From: Simon Davis
Sent: 12 July 2019 14:19
To: Planning.Responses <Planning.Responses@arun.gov.uk>
Subject: FW: Y/46/19/DOC New Gospel Hall, North End Road, Yapton - Insulation Details

They have submitted a plan called "Construction Dwg No 331 Rev A"

Drawn MB	Date 24/09/2015	Checked AB	Date 25/09/2015	Scale at A3 1:5
Job N°. 14.032	Drawing N°. 331	Rev. A		
Status

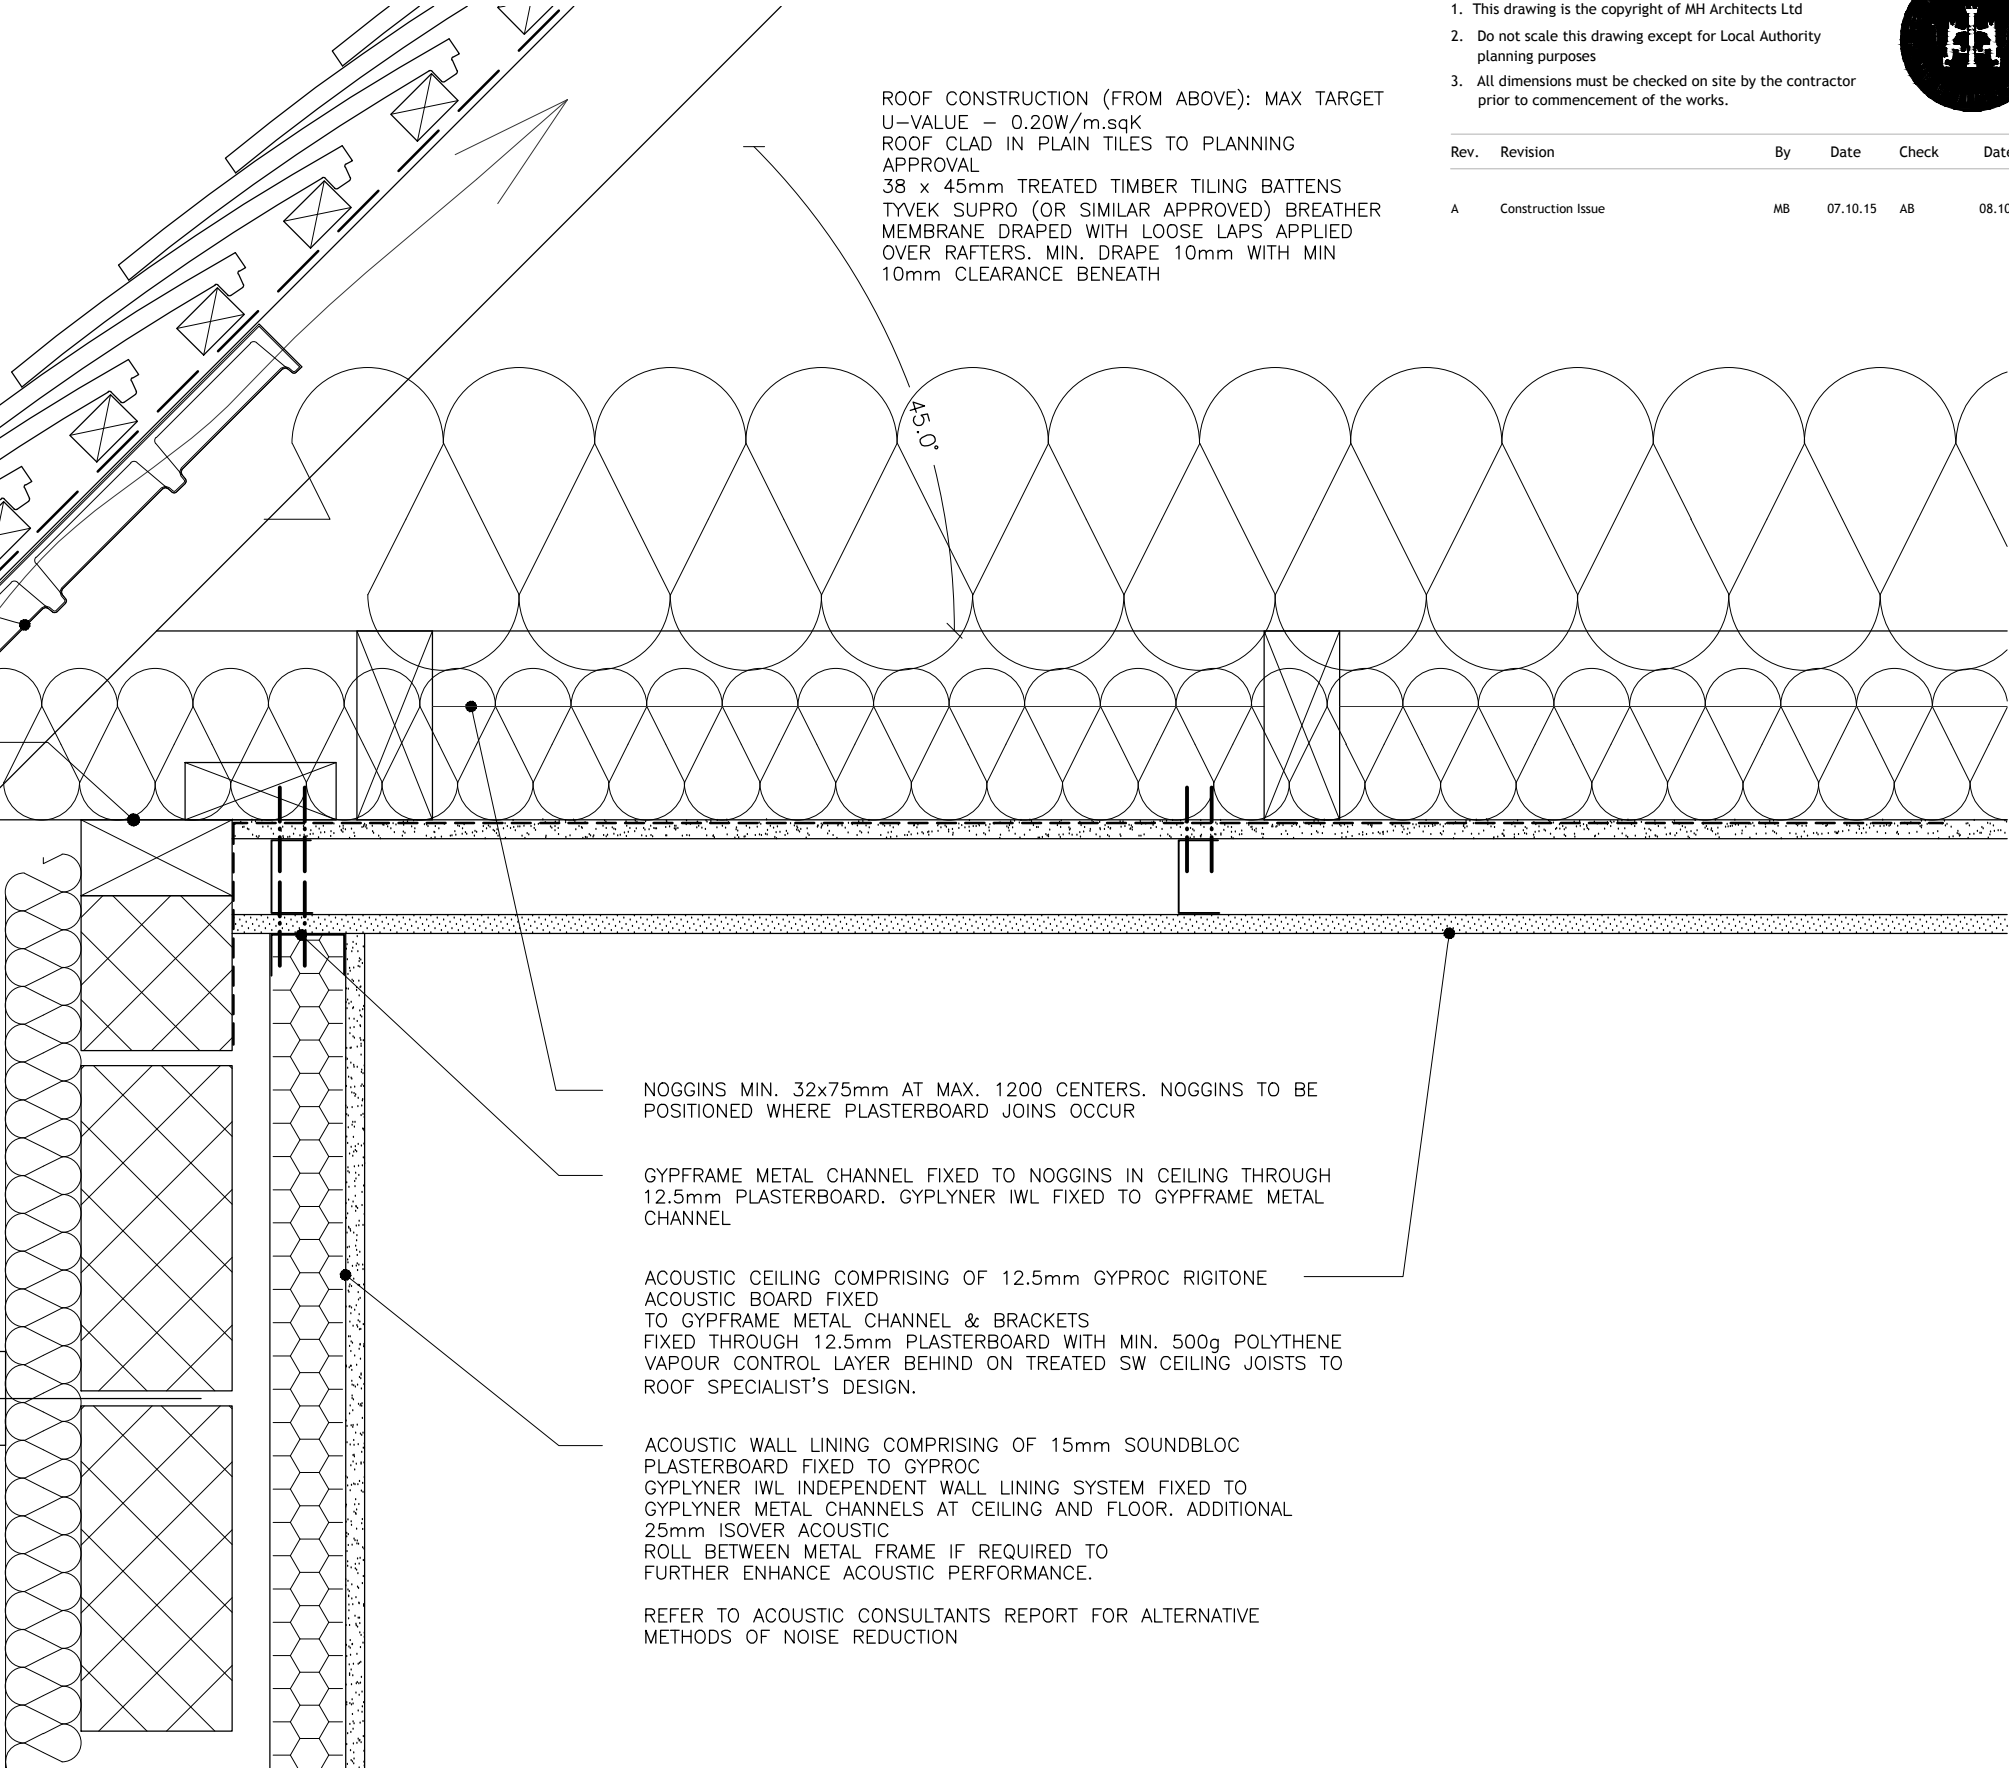
As I understand, condition 10 requires that the building be insulated in accordance with an approved noise management scheme, however the submitted document does not adequately address this condition. Based on the proposed use, the scheme should identify the potential sources of noise and illustrate the levels of noise. The scheme should then demonstrate how the noise will be managed to an acceptable level. The applicant may wish to engage the services of a suitably qualified, independent acoustic consultant to assist with this aspect. Whilst the Council cannot recommend companies, there is a list of approved acoustic consultants based in East and West Sussex which I can supply if requested.
